STERLING RECYCLING SUBDIVISION

LOCATED IN THE NW1/4 OF THE NW1/4 OF SECTION 4 & THE N1/2 OF SECTION 5,
BOTH IN TOWNSHIP 13 SOUTH, RANGE 65 WEST OF THE 6TH PRINCIPAL MERIDIAN
COUNTY OF EL PASO, STATE OF COLORADO

V1_Final Plat Drawings.pdf Markup Summary

STERLING RECYCLING SUBDIVISION

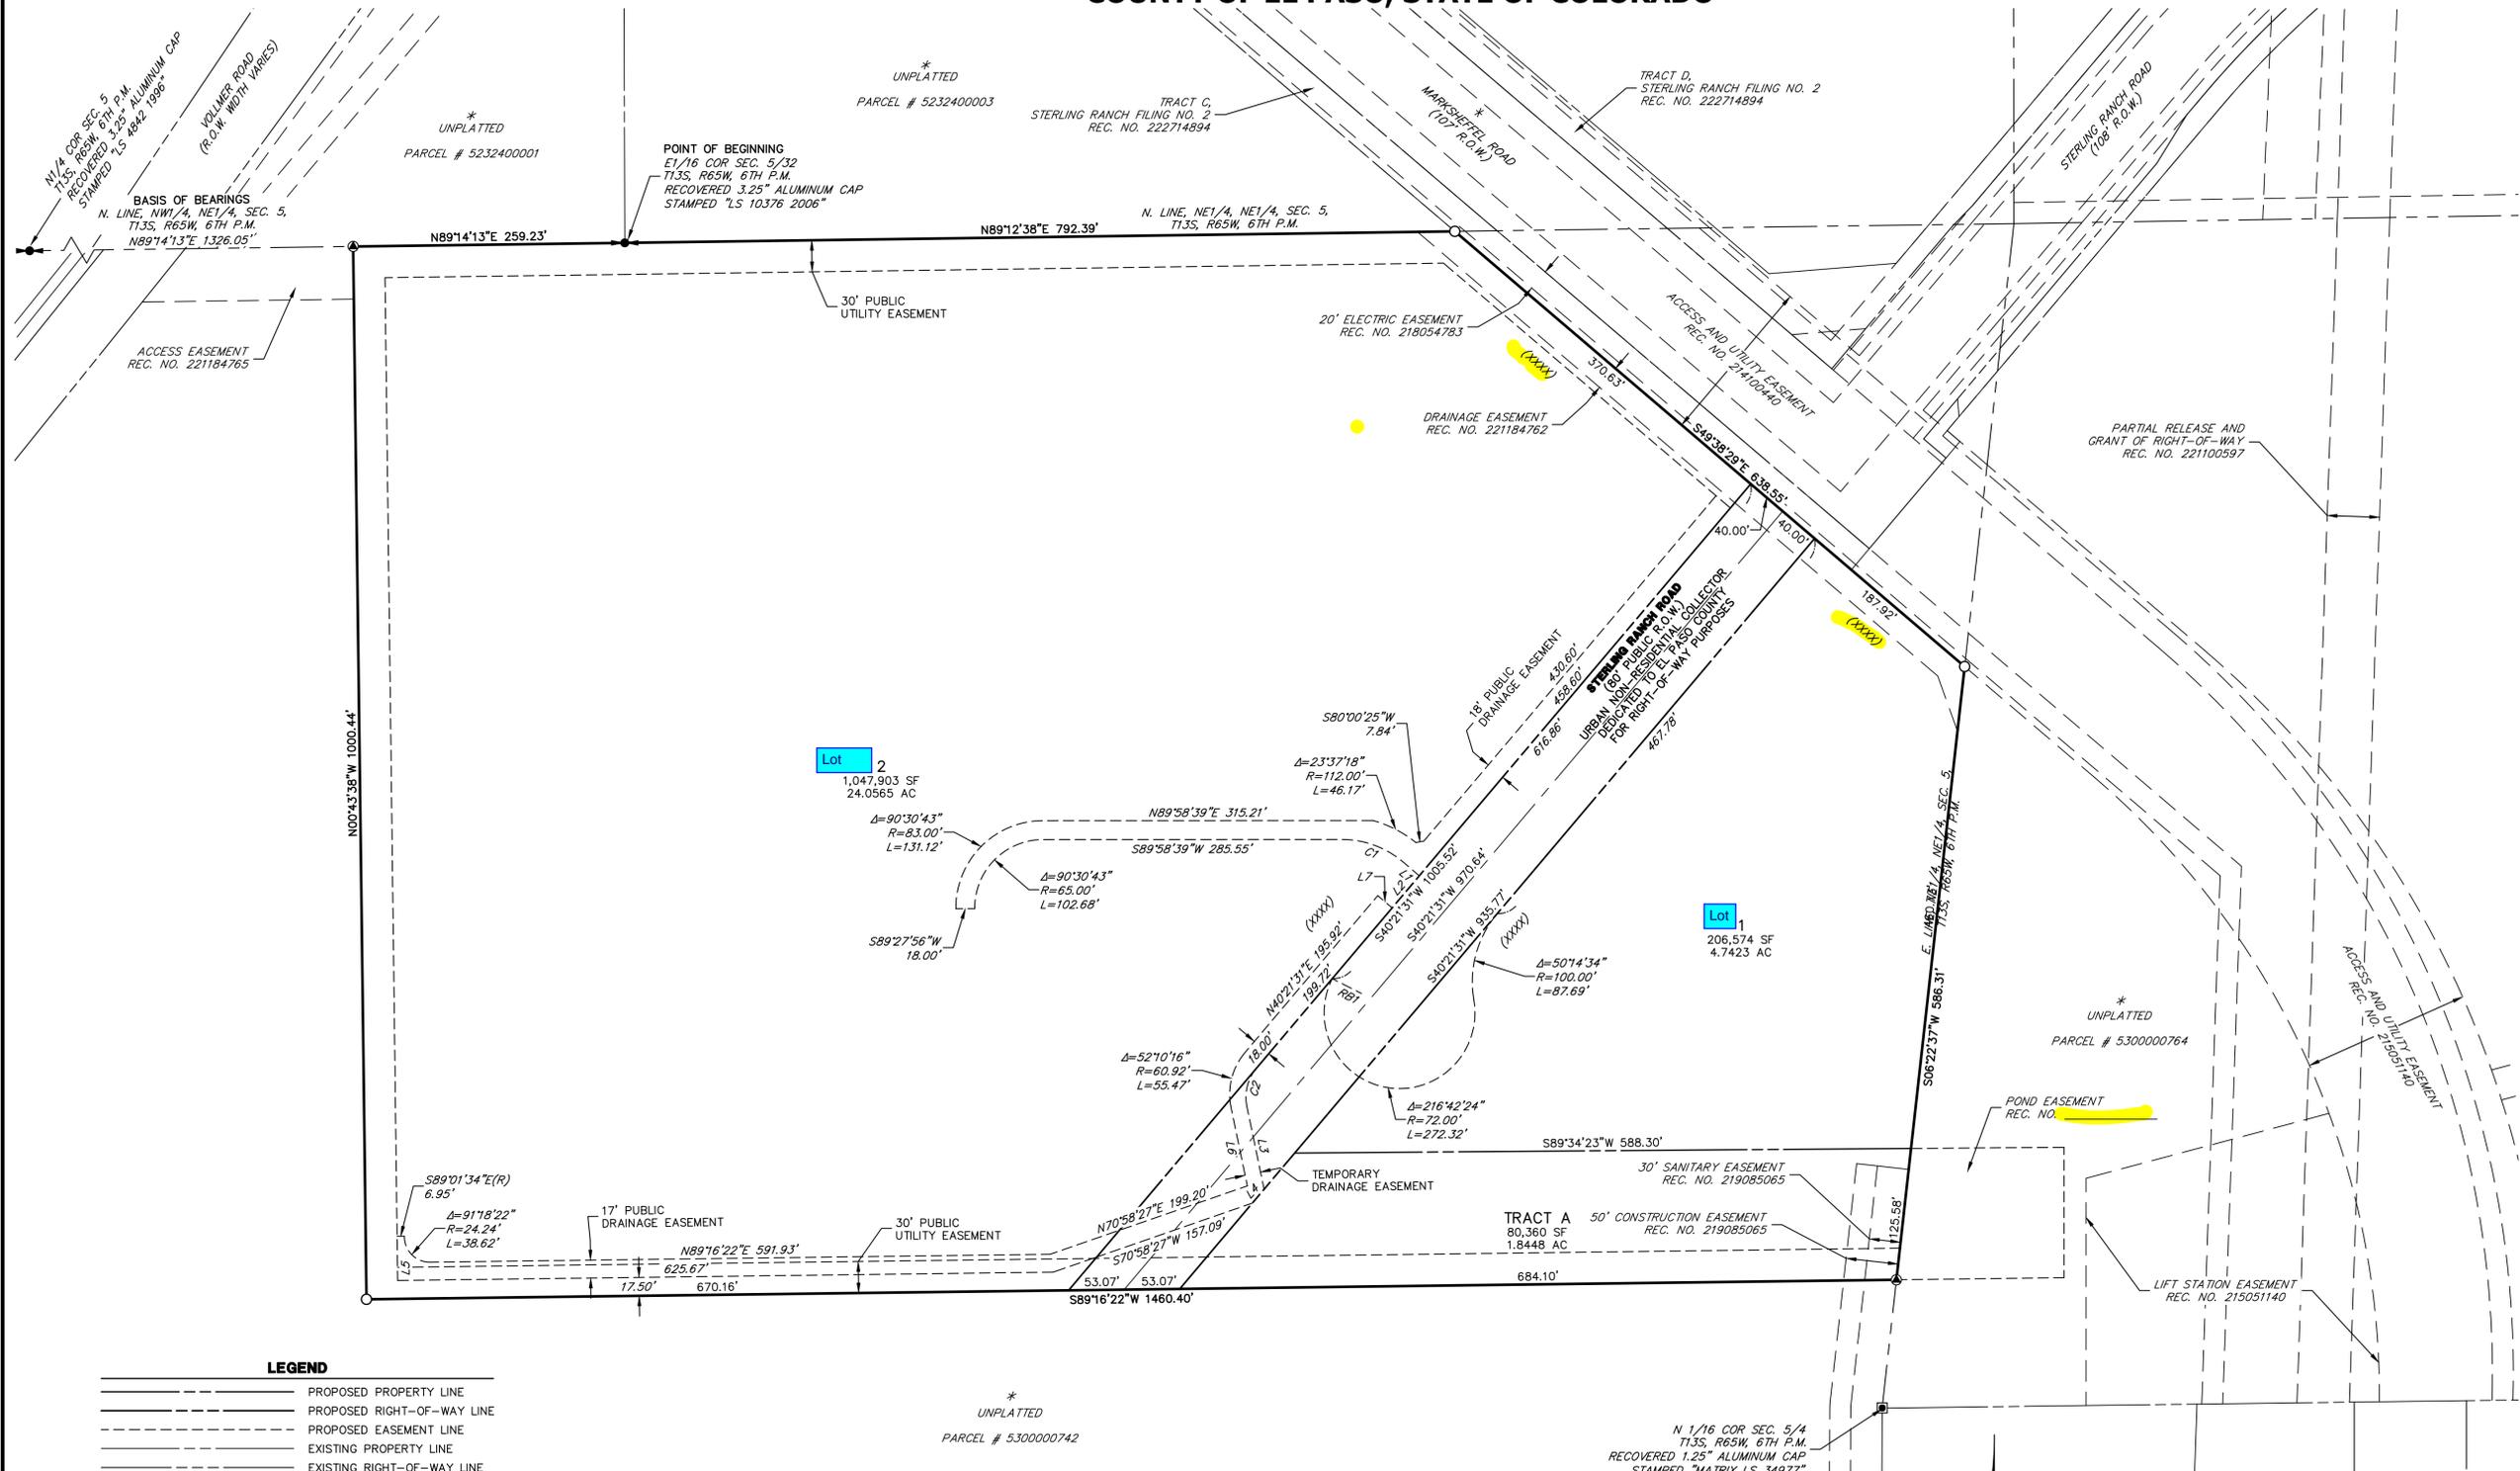
For Swales DP2, DP4, and DP4.1:
Per ECM 3.3.4.A, ditches in developments (roadside ditches excluded) that convey more than 15cfs should be in drainage easements. Please create drainage easements and reflect them on the plat.

Add missing temp cul-de-sac and temp easement

This seems to include the Tract A acreage ROW is ~1.72ac
Tract A ~ 1.85
LOT 1 24.05ac
LOT 2 ~ 5ac
please verify all lot ac

Add missing tract area and pond easement to include maintenance access easement. Call out Tract A acreage

Show off lot pond easement with Rec #
